Comments for Planning Application 24/00171/OUT

Application Number: 24/00171/OUT

Address: 24 High Street Cullompton Devon EX15 1AA

Proposal: Outline for the erection of a dwelling with some matters reserved and additional parking for No 24 High Street

Proposed Site Plan
scale 1:200

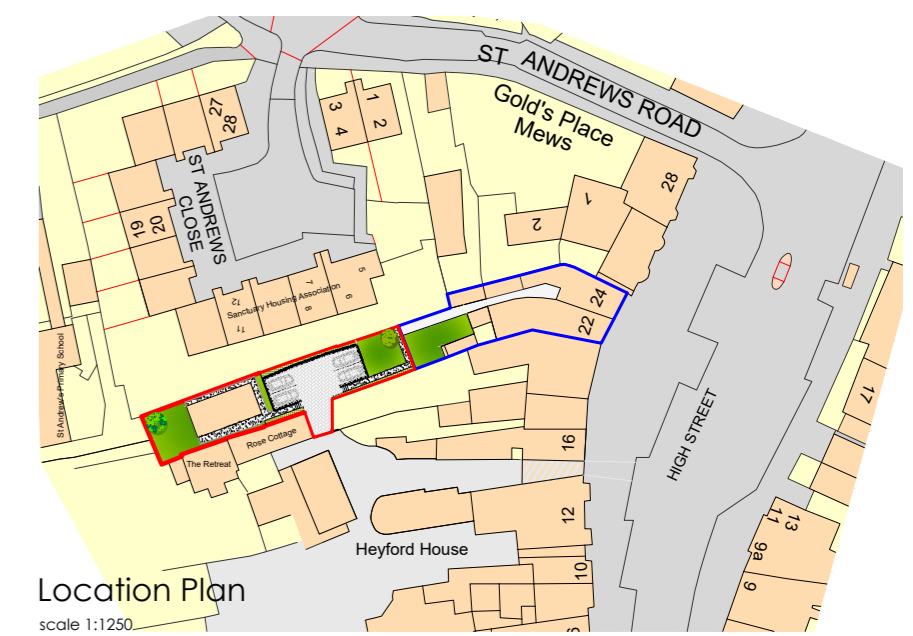
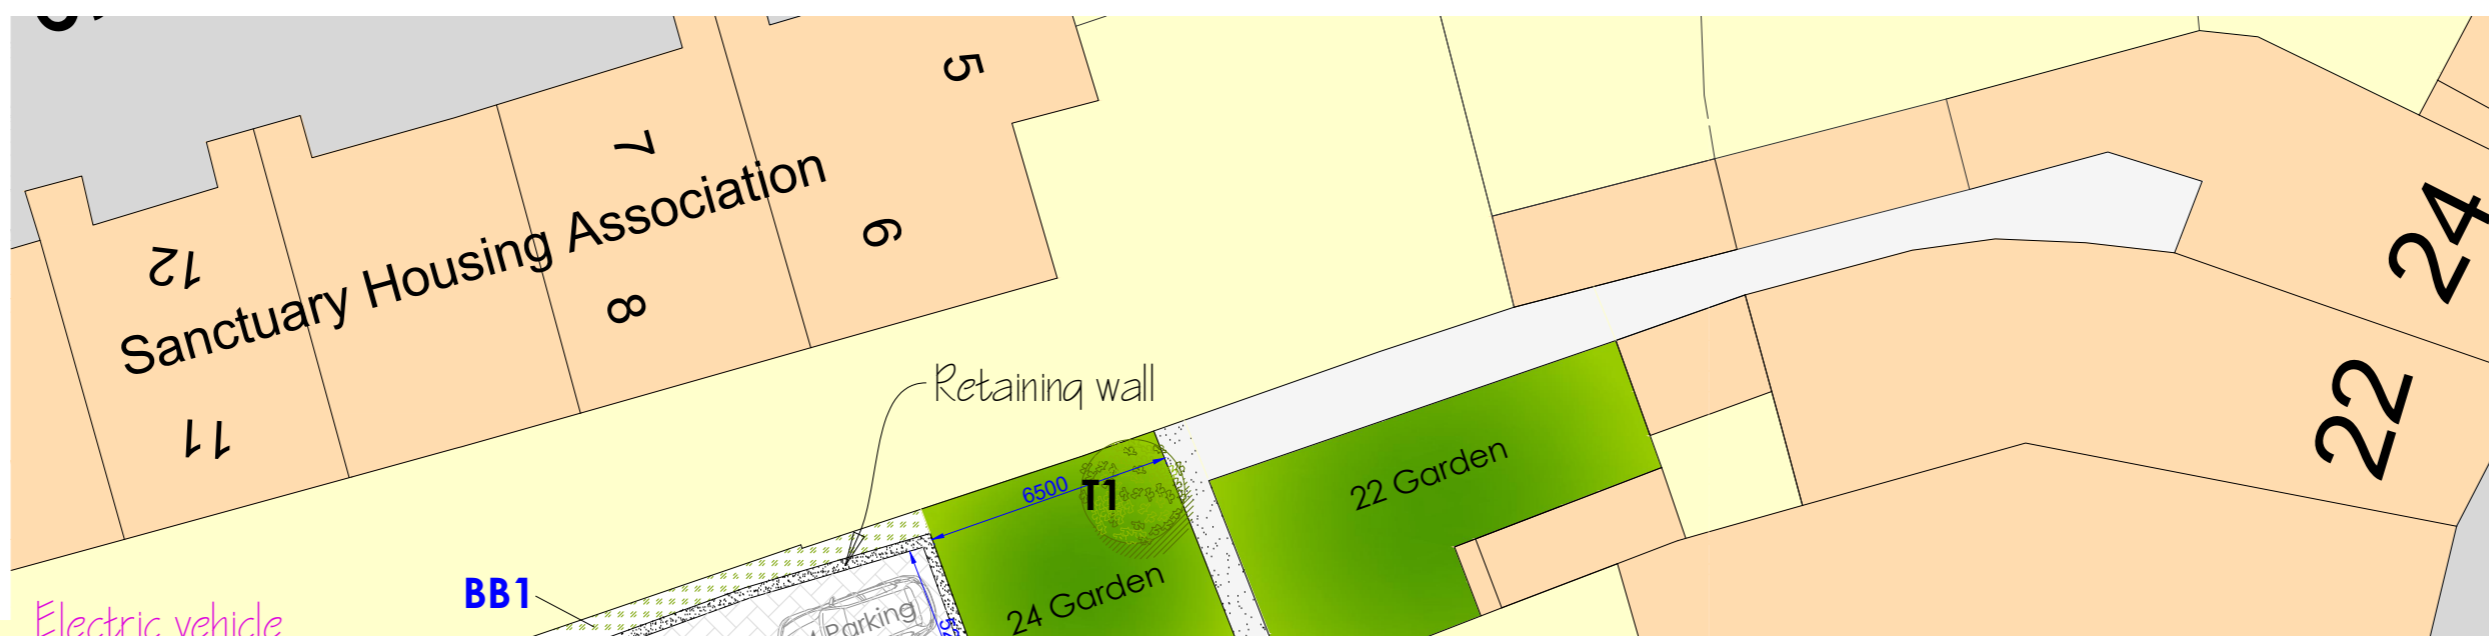
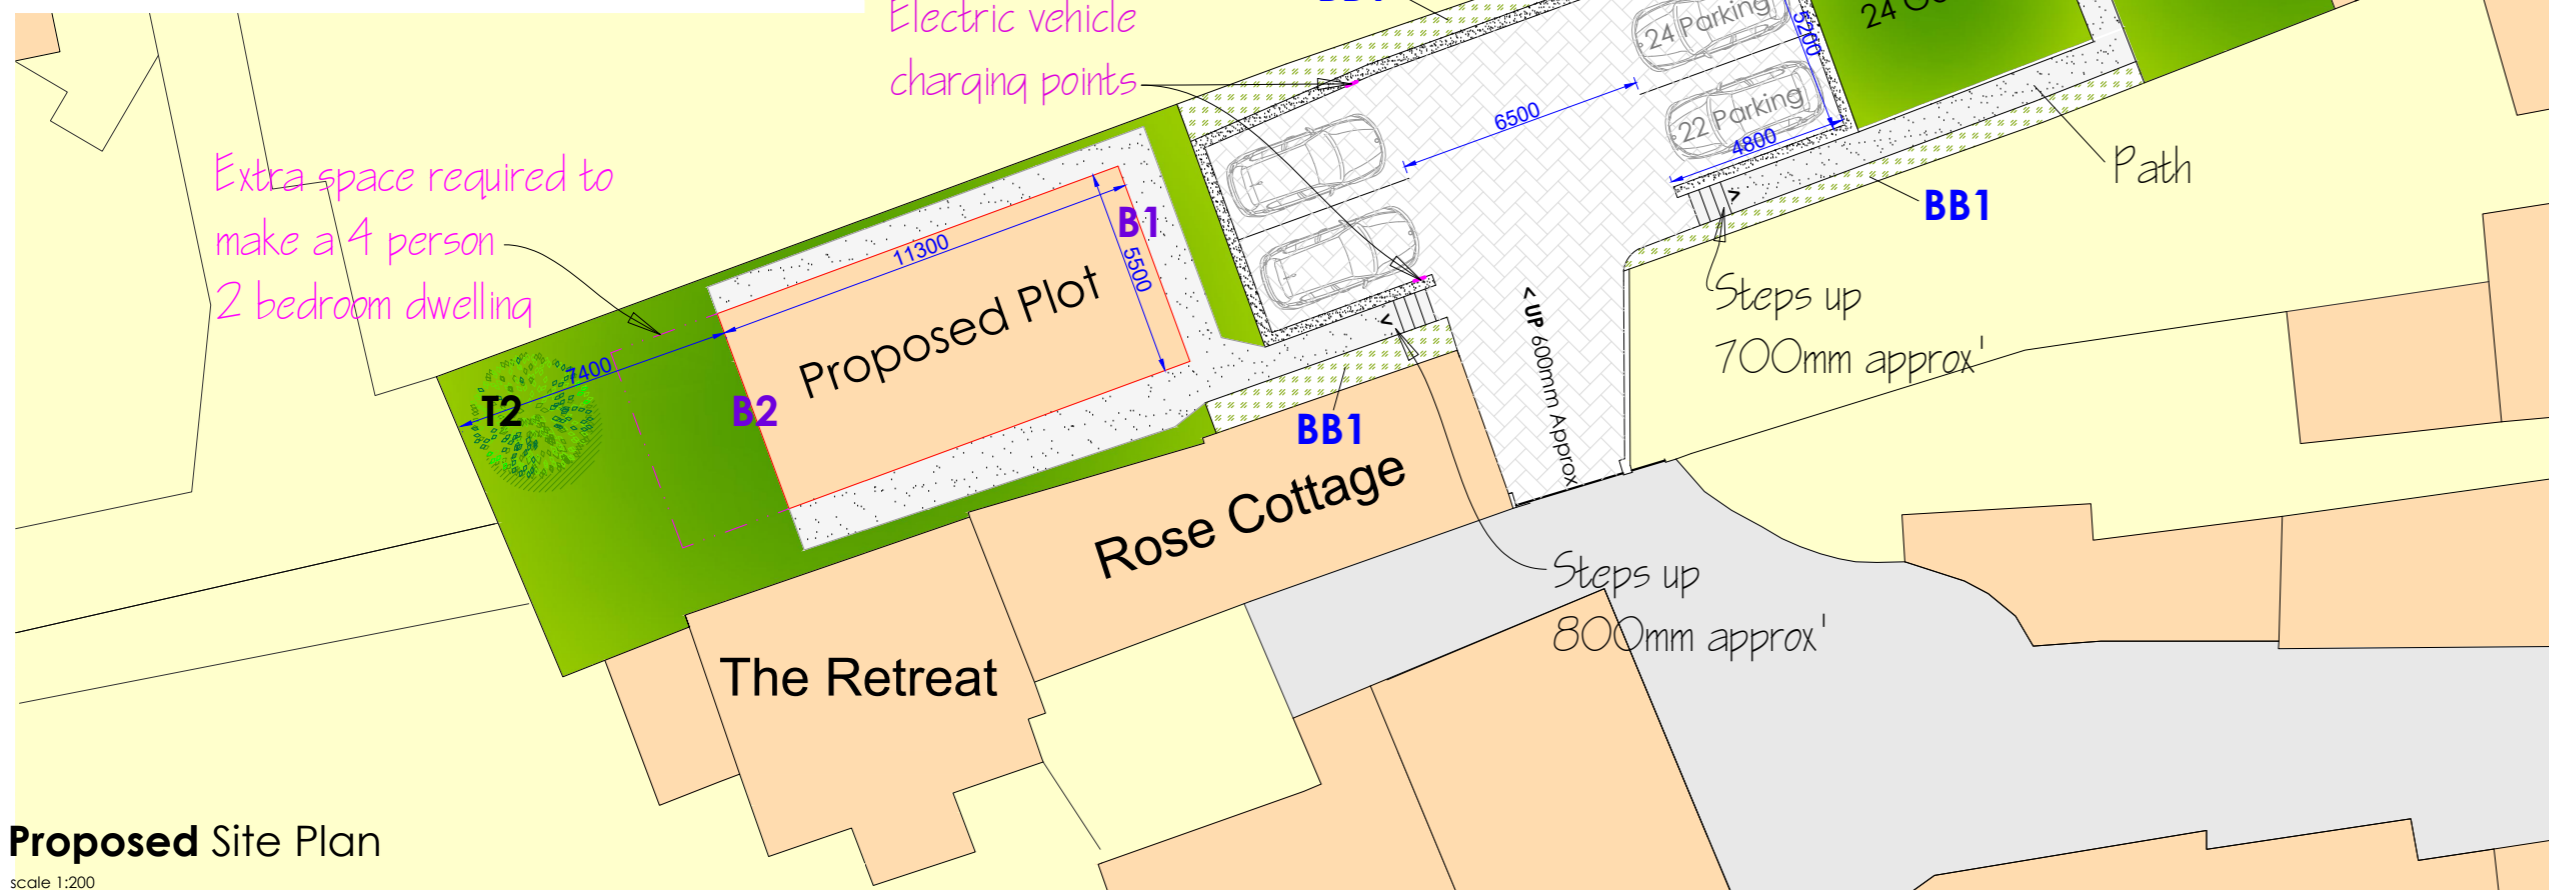
Comment: The access directly adjoins our property and is very restricted and not suitable for more vehicles. The area in front of the garage is a shared piece of land and is frequently used for parking, it is not owned by 24 High Street and is constantly in use by others. More vehicles over our current access from the High Street will further damage the surface and the utilities running underneath.
